Appeal Decision

Appeal Ref: 6011584

Eastlyn, Fengate, Moulton Chapel, Spalding PE12 0XL

- The appeal is made under section 78 of the Town and Country Planning Act 1990 (as amended) against a refusal to grant planning permission.
 - The appeal is made by Mrs Gemma Toms against the decision of South Holland District Council.
 - The application Ref is H13-0359-26.
 - The development proposed is existing rear extension to be demolished and replaced with proposed rear extension.
-

PROPOSED REAR ELEVATION

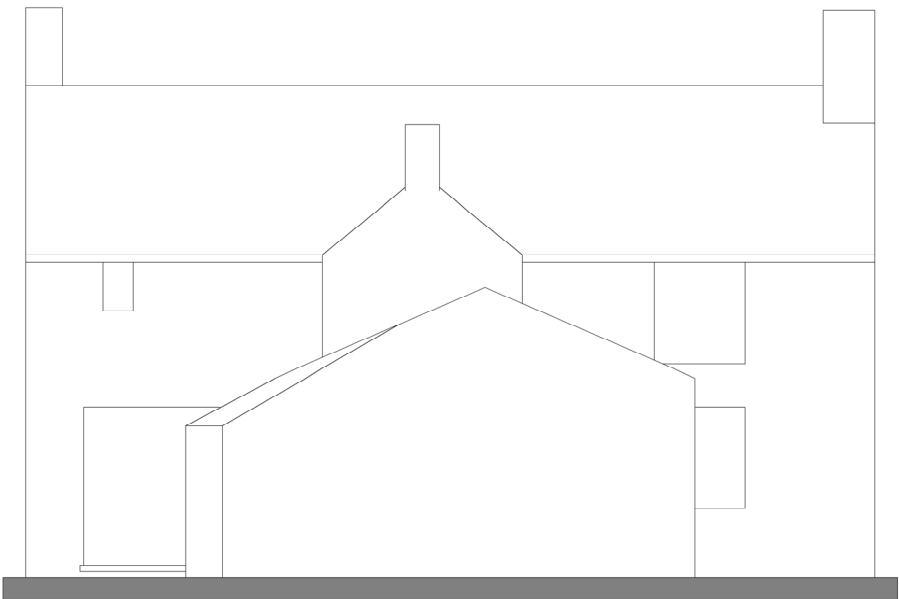
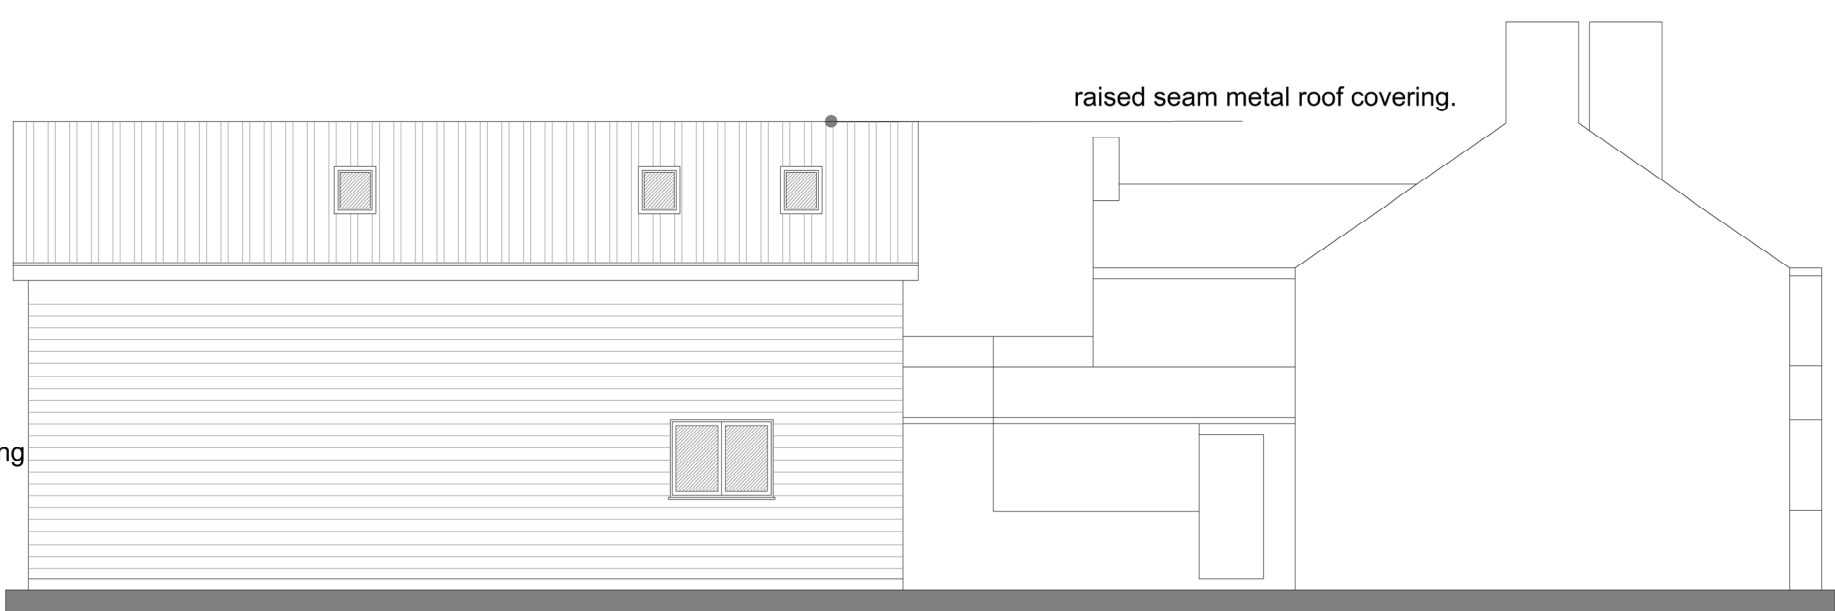
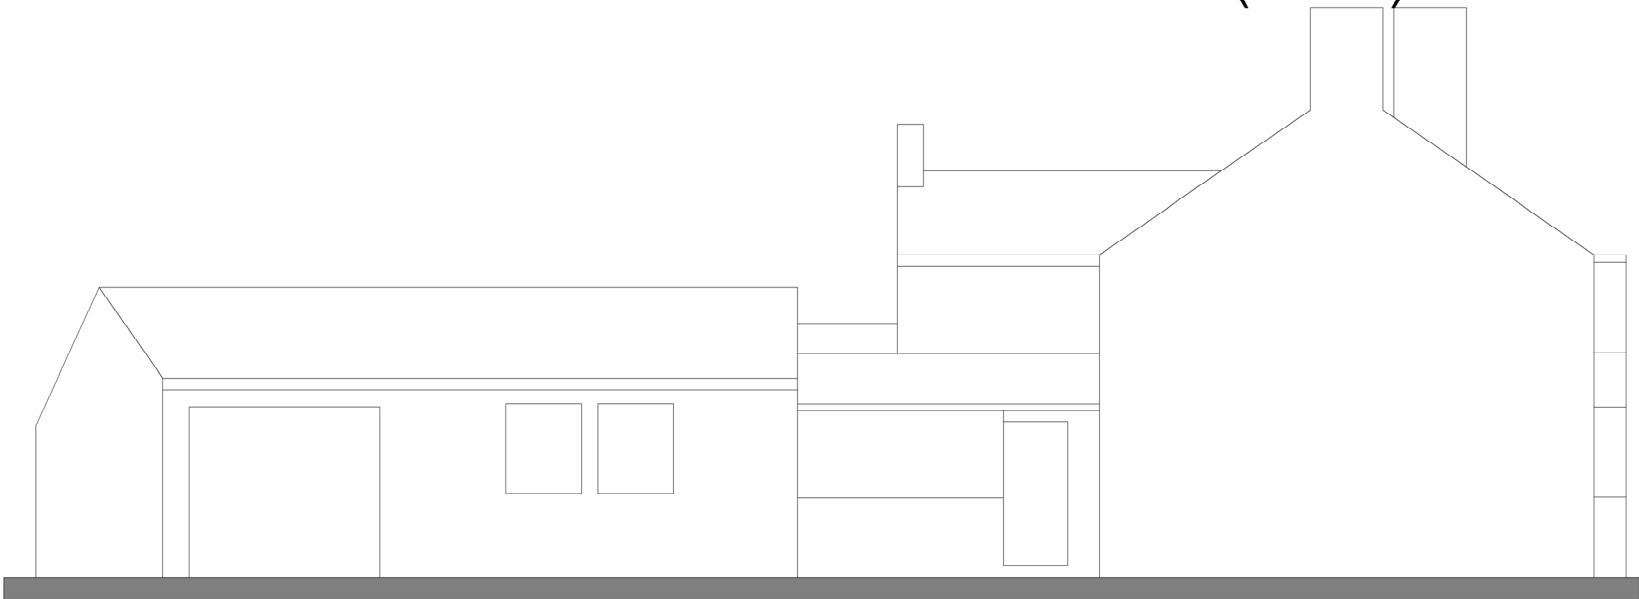
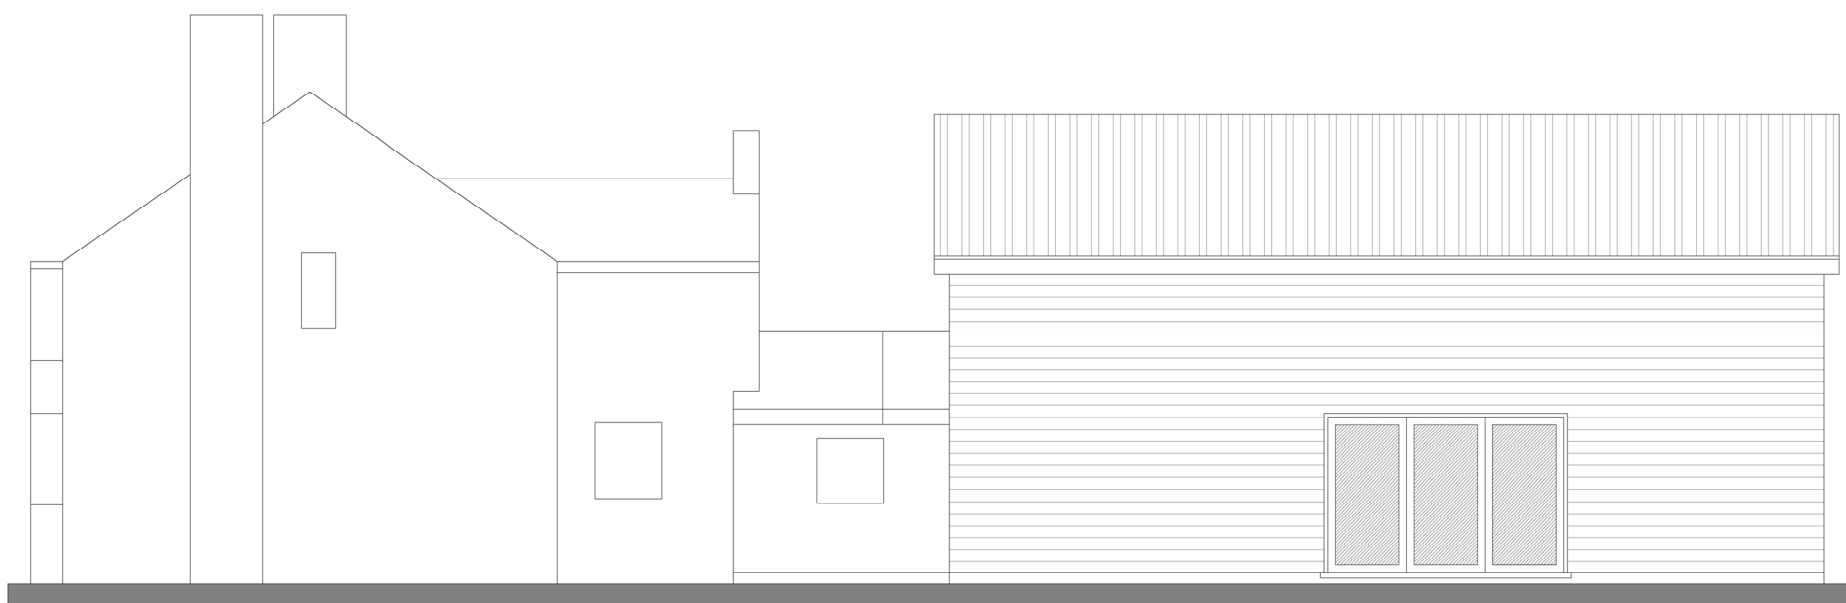
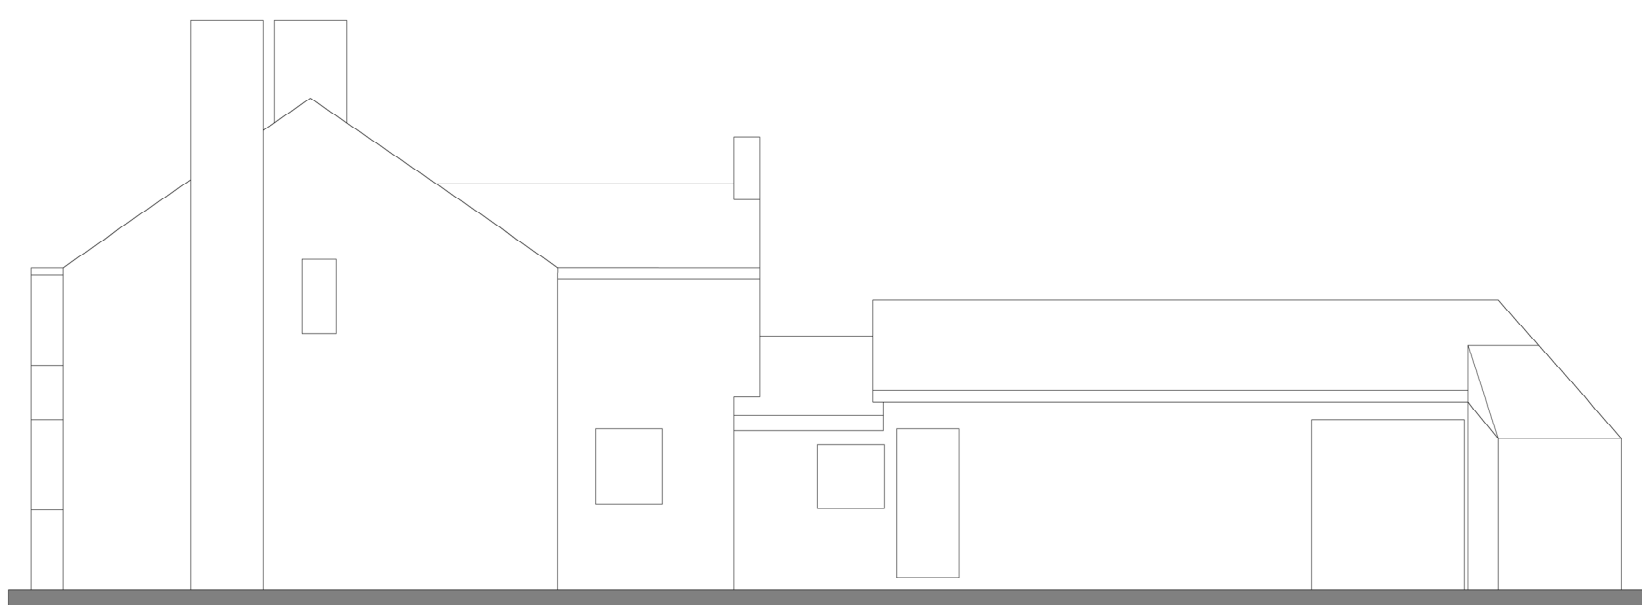
5. Whilst the proposed extension would sit below the ridge line of the existing dwelling and would therefore appear subservient in height, this factor alone is not determinative. The overall scale, footprint and massing of the development would be substantial and would not appear subordinate to the host dwelling when viewed as a whole. This impression would be reinforced by the single-storey linking elements, which would visually extend the built form between the two-storey components and increase its overall presence.

6. Given the site's prominent corner location and the close proximity of the building to the site boundaries, the extension would be highly visible within the street scene, further emphasising its substantial presence. Whilst some filtering of views may be provided by existing landscaping in the locality, this cannot be relied upon as a

7. It is indicated that the proposal would be constructed in black weatherboard cladding with a standing seam metal roof. Whilst this contemporary palette of materials would contrast with those of the existing dwelling, I do not concur with the Council that this would be inappropriate given the rural context of the site's surroundings. Nevertheless, the use of high-quality materials would not overcome the harms identified.
8. For the reasons stated, I conclude that the proposal would be materially harmful to the character and appearance of the area. This draws it into conflict with Policies 2 and 3 of the South East Lincolnshire Local Plan (2019) insofar as they require development to be of an appropriate size, scale layout, having regard to the character and appearance of the area and the relationship to existing development and land uses.
